**KIRKLEES METROPOLITAN COUNCIL
INVESTMENT & REGENERATION SERVICE**

**DELEGATED DECISION TO DETERMINE APPLICATIONS FOR
CONSENT, AGREEMENT OR APPROVAL REQUIRED BY CONDITION**

Reference No:	2024/44/93179/E
Site Address:	adj, 33a, Church Lane, Clayton West, Huddersfield, HD8 9LY
Description:	Discharge of conditions 6 (boundary treatments), 10 (potential land contamination), and 15 (Arboricultural Method Statement and Tree Protection Plan) of previous permission 2023/91483 for demolition of garage and erection of detached dwelling
Recommending Officer:	Elenya Jackson

DECISION – REFUSE DISCHARGE OF CONDITIONS

Appendix 2 – Tree Survey

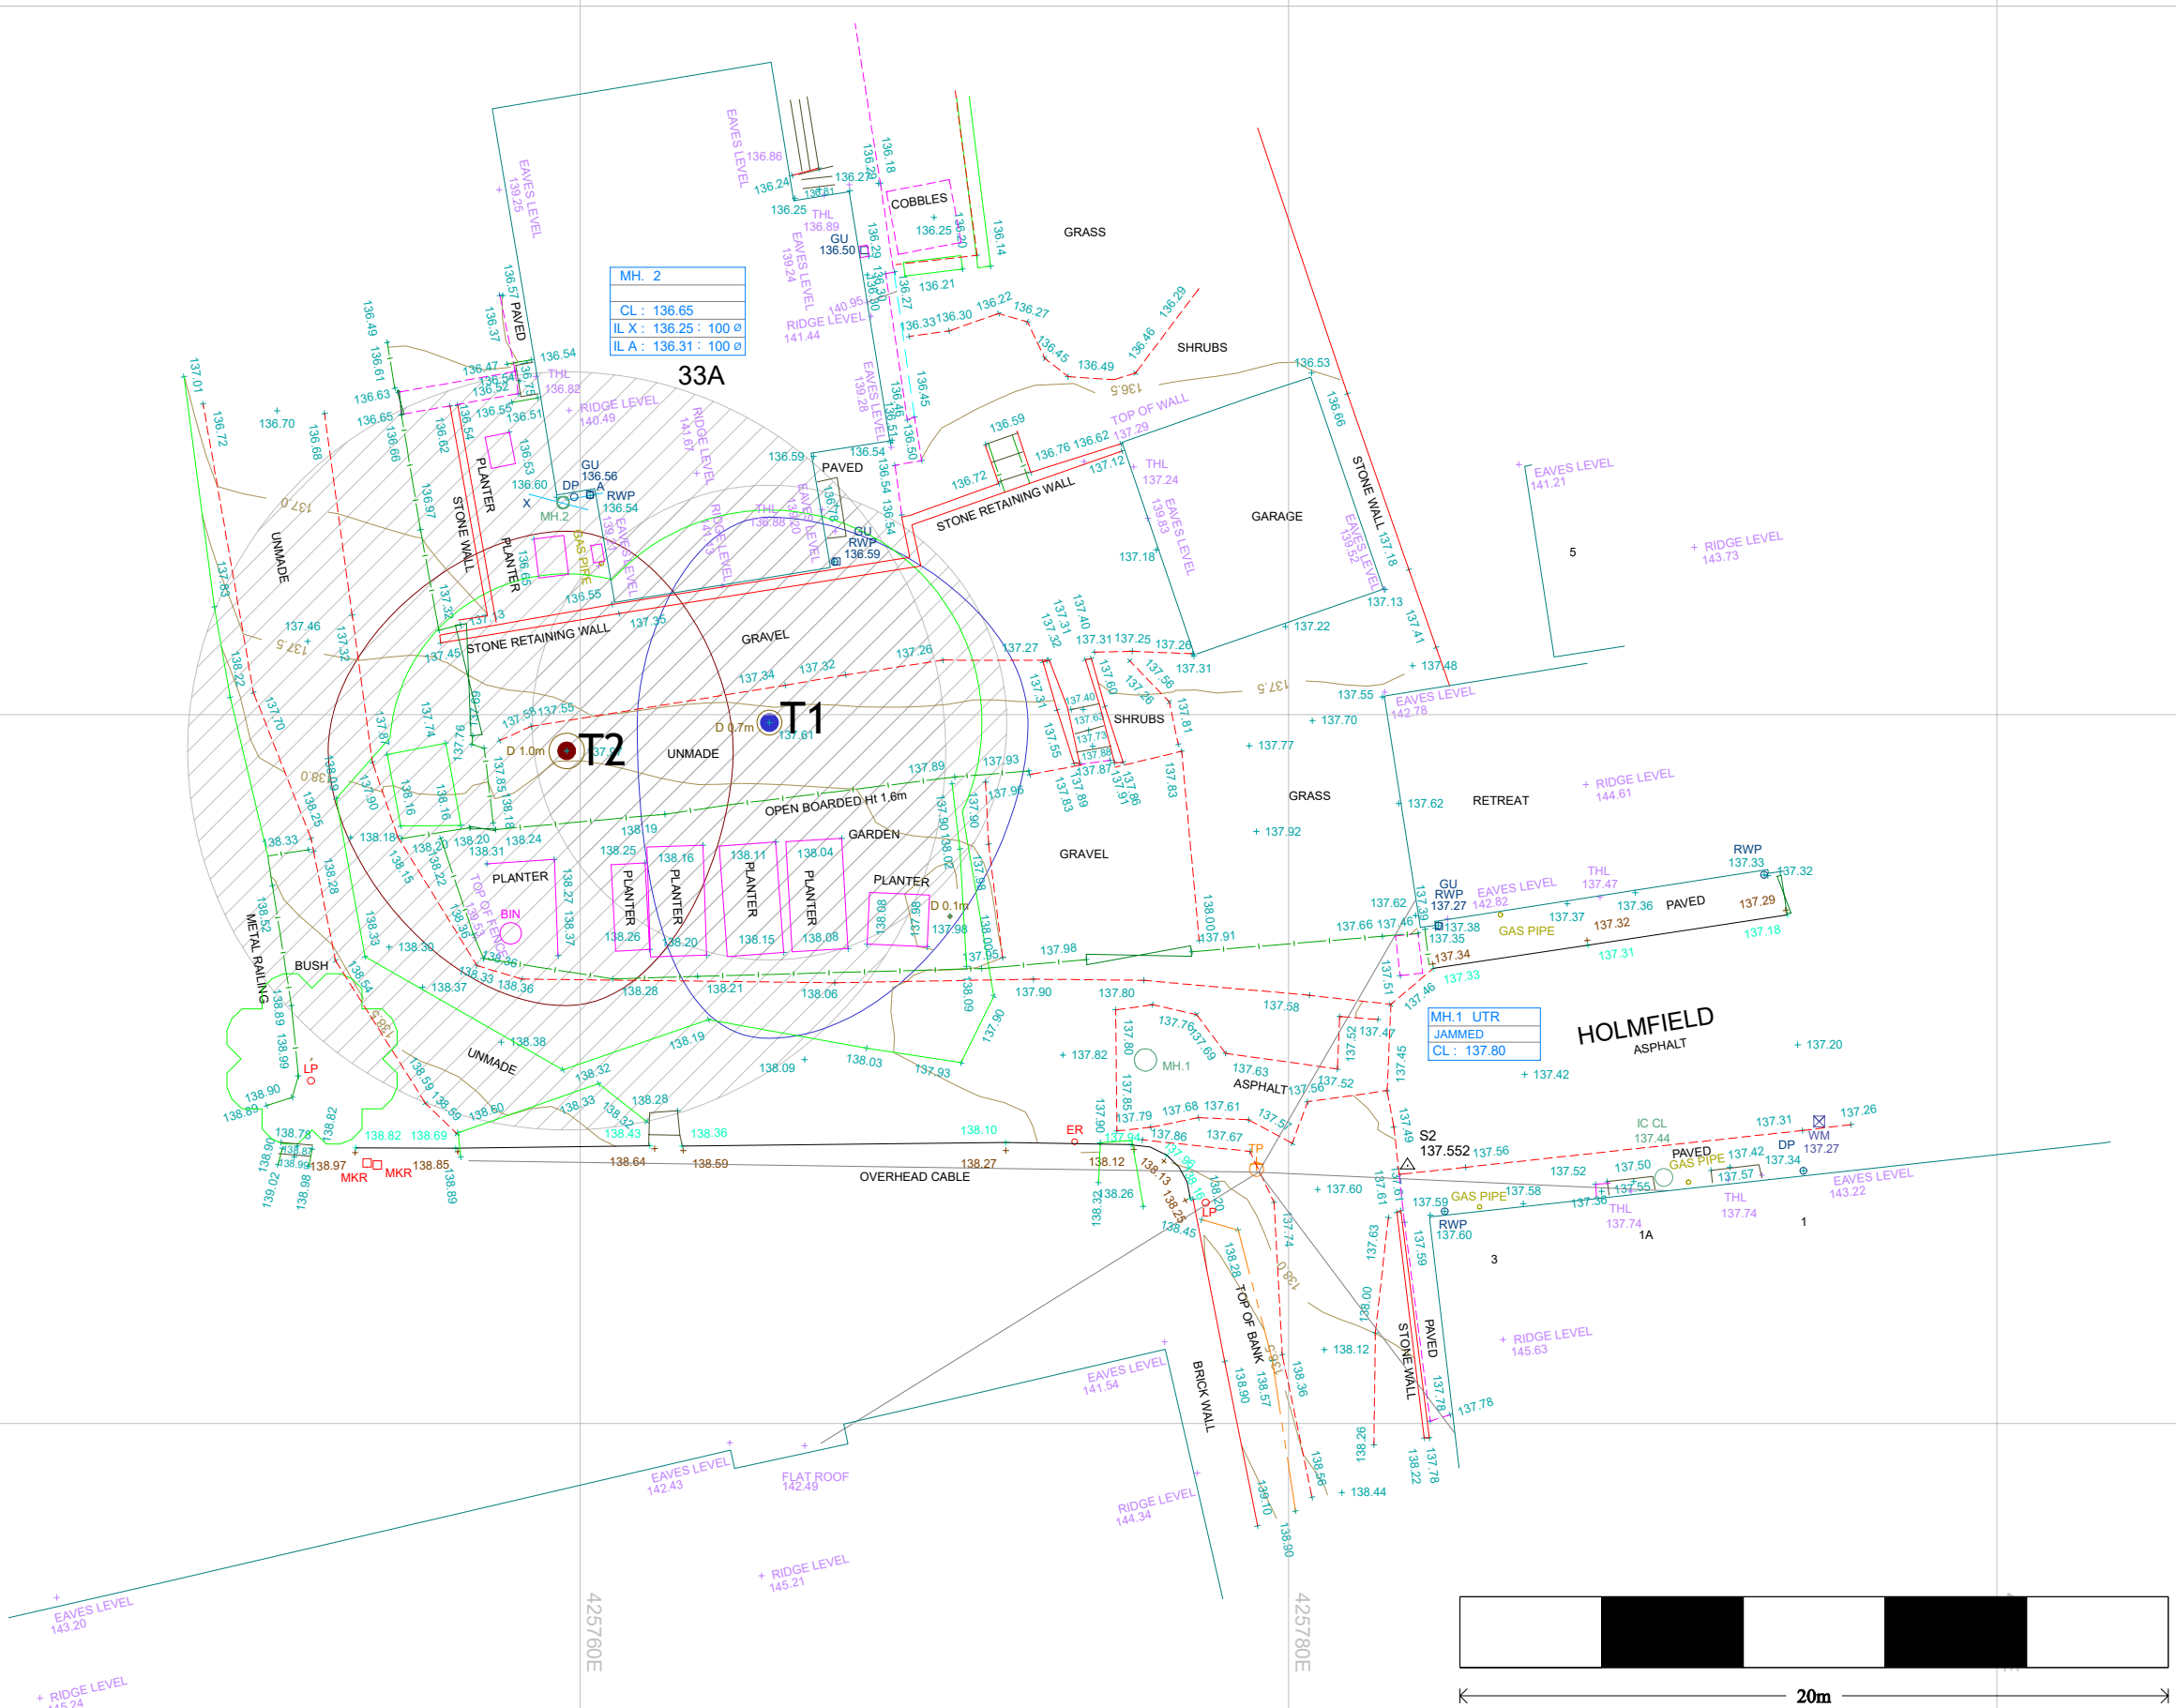
There are currently discrepancies in the submitted information relating the status of T2 (Horse Chestnut). The permission granted for tree works on this site is for the crown lifting to 5 meters above ground level for both T1 and T2 as shown in appendix 1 of the submitted AMS. However, in appendices 3 and 4 of the AMS it reiterates the previously refused recommendations to remove T2.

Appendix 2 Tree Protection Plan

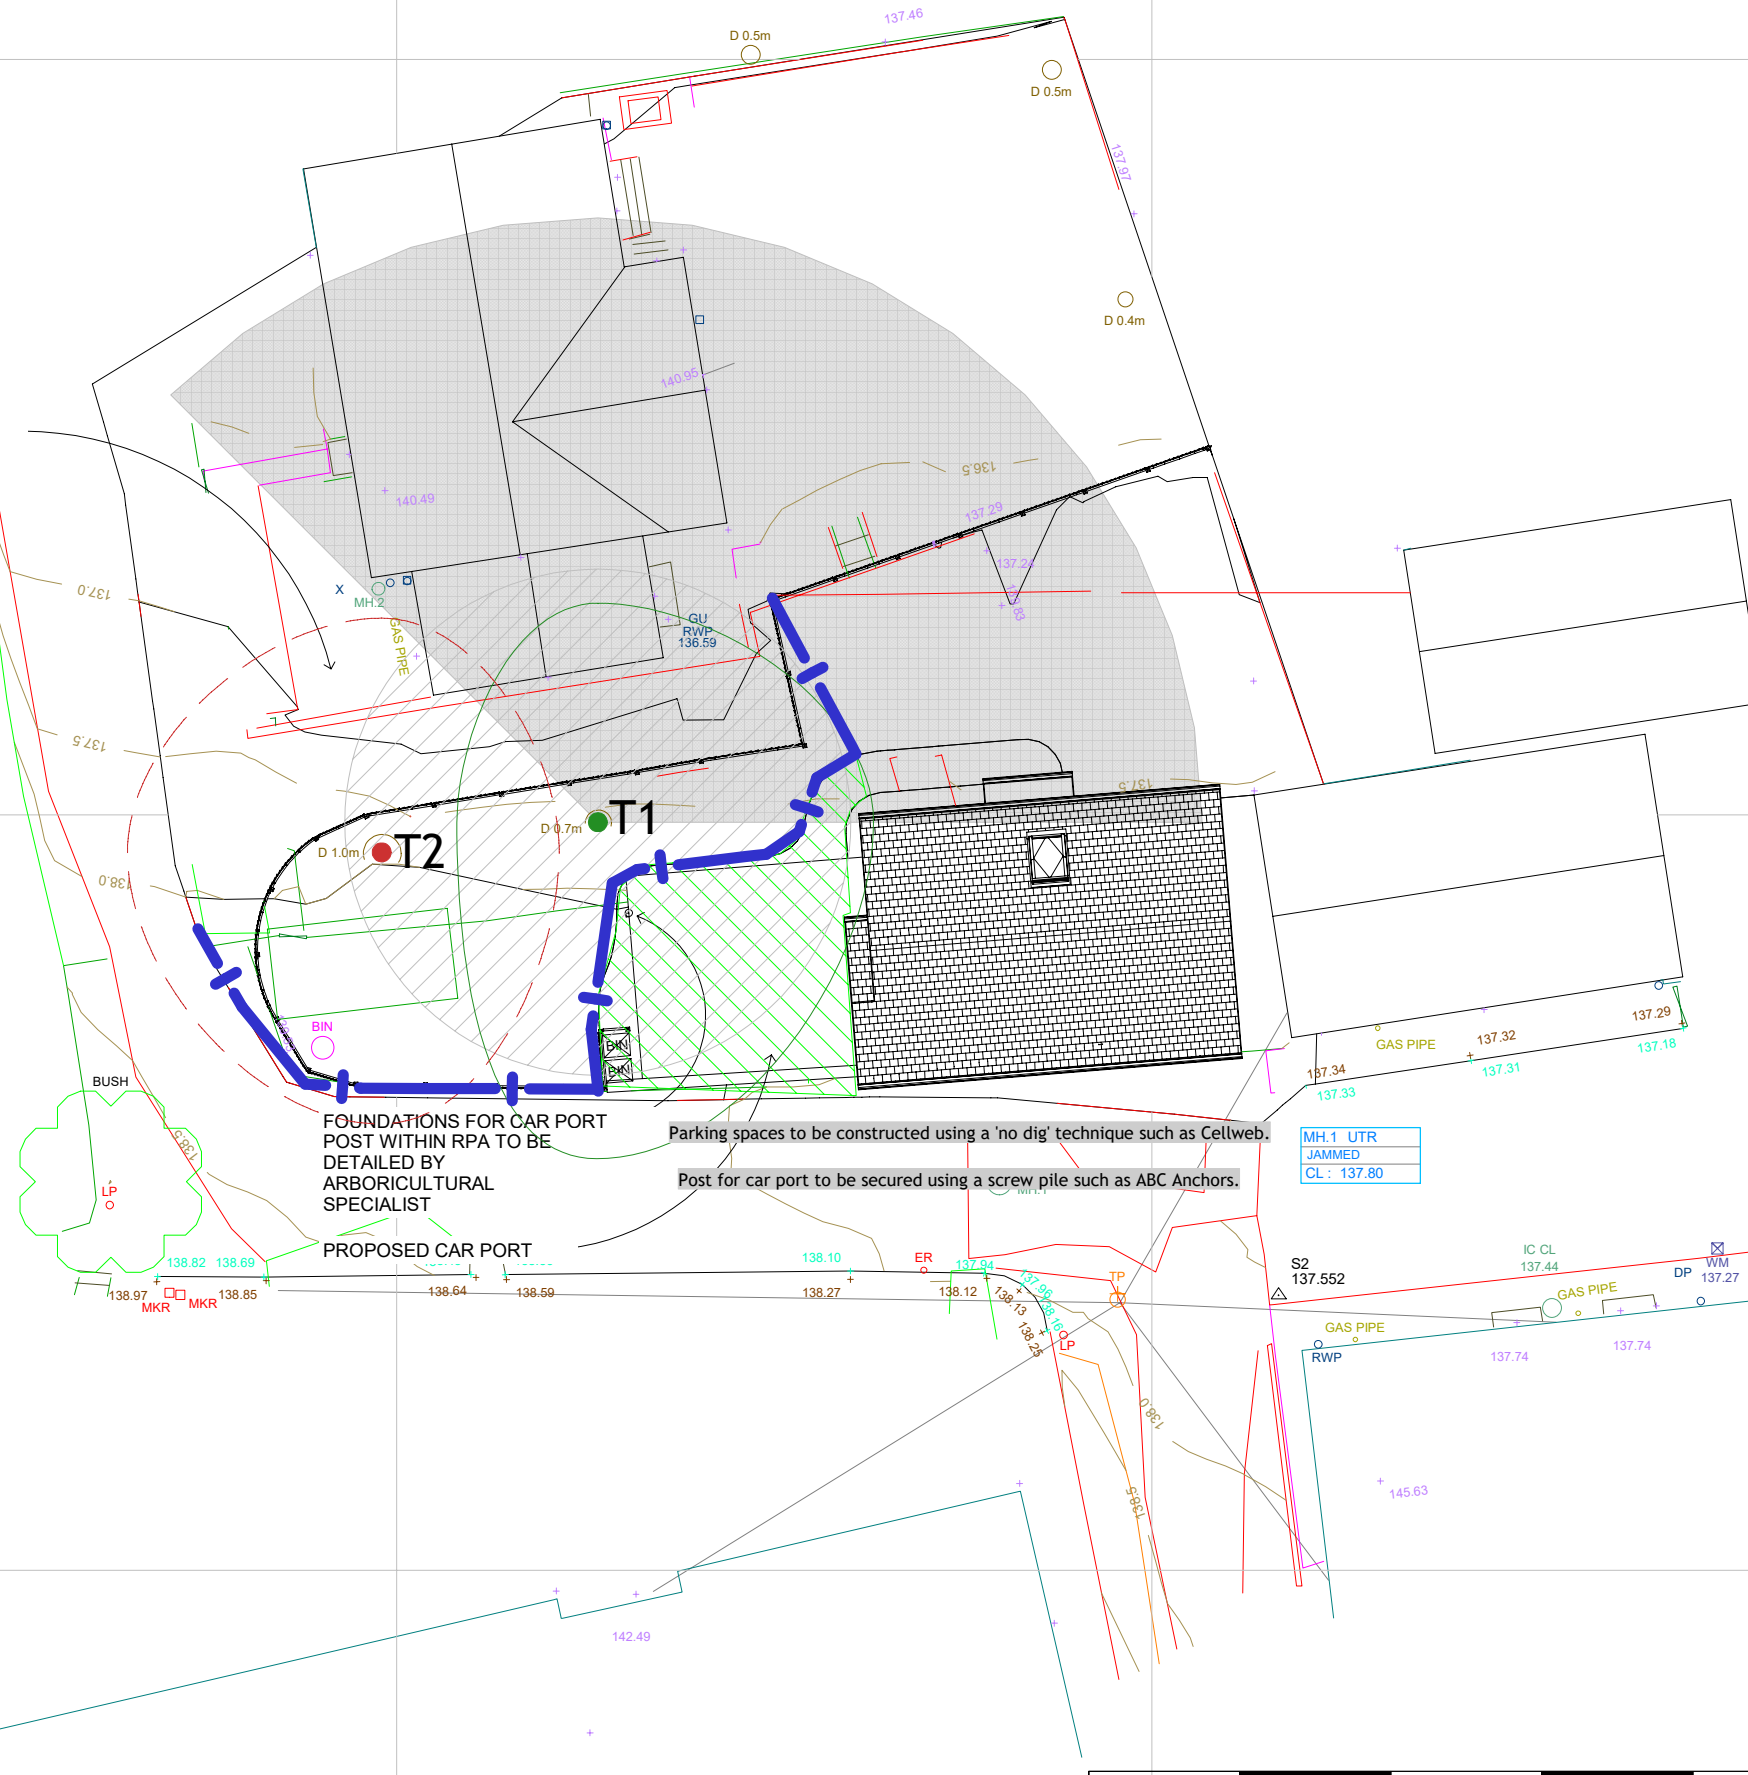
It is unclear whether the submitted statement intends to remove T2 or retain it. To reiterate, existing permissions only allow for crown lift T2. Also, the report further states “T2 to be removed per James Royston Report” whilst also appearing to lay out tree protection fencing for T2.

Therefore, the details submitted are not considered acceptable as the submitted documents contain conflicting information. Clarification is required regarding the intended work to T2.
